**App No:** LU/162/17/PL

**Address:** Land North & West of Toddington Farm Cottages Toddington Lane  
Wick Littlehampton BN17 7PP

**Proposal:** Demolition of existing building, erection of 10 residential dwellings  
(Use Class C3) with associated open space, landscaping, parking,  
and access. Departure from the Development Plan.

Environment Officer  
Environment  
Chichester District Council

Figure 7. Proposed locations of the two bat access tiles shown with red circles.

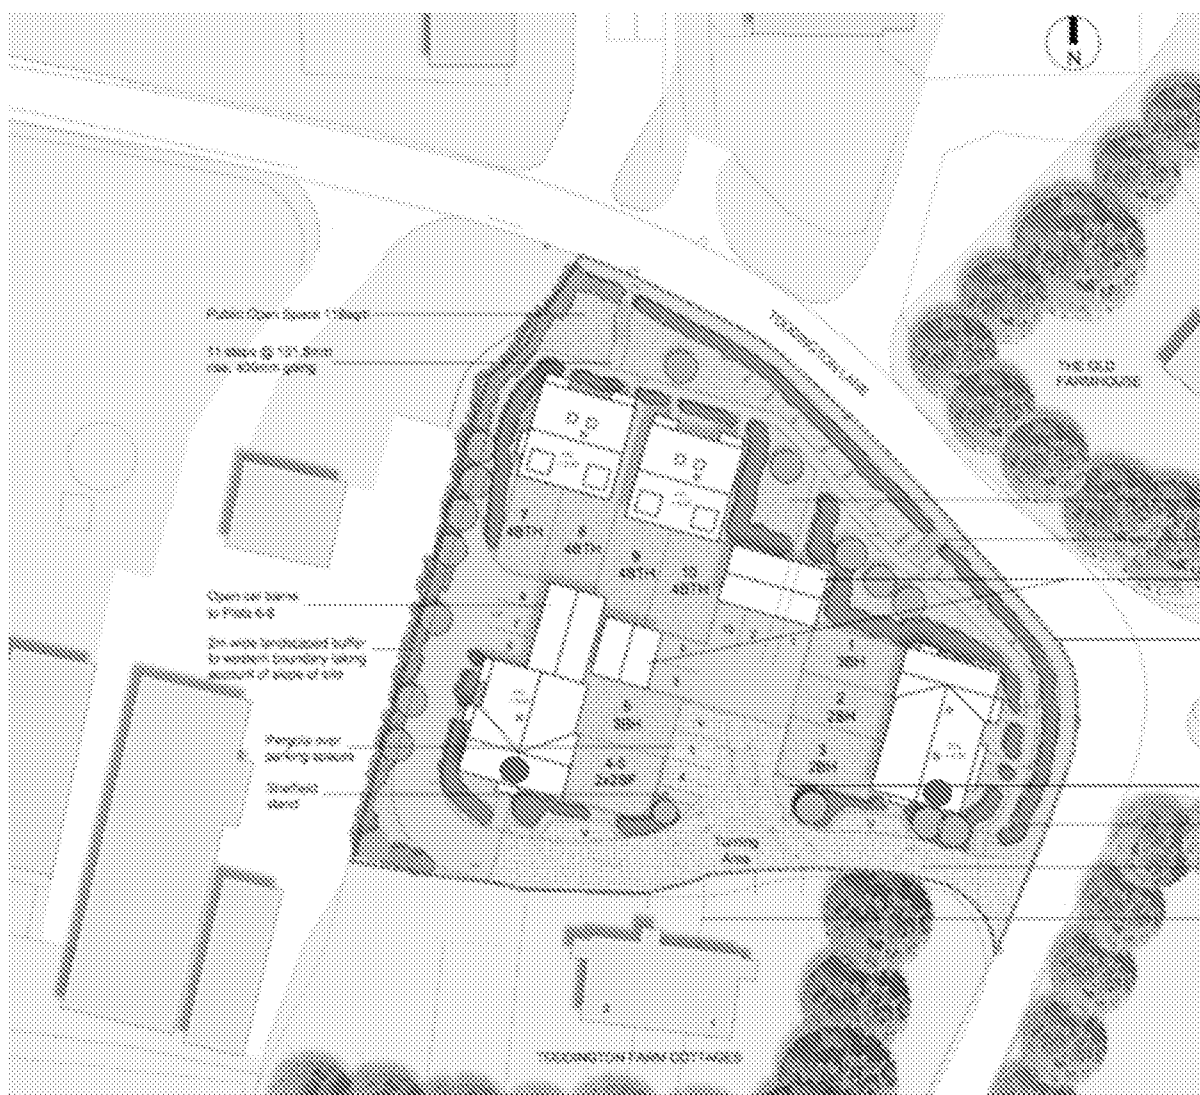
The lighting scheme for the site will need to take into consideration the presence of bats in the local area and the scheme should minimise potential impacts to any bats using the trees, hedgerows and buildings by avoiding unnecessary artificial light spill through the use of directional light sources and shielding.
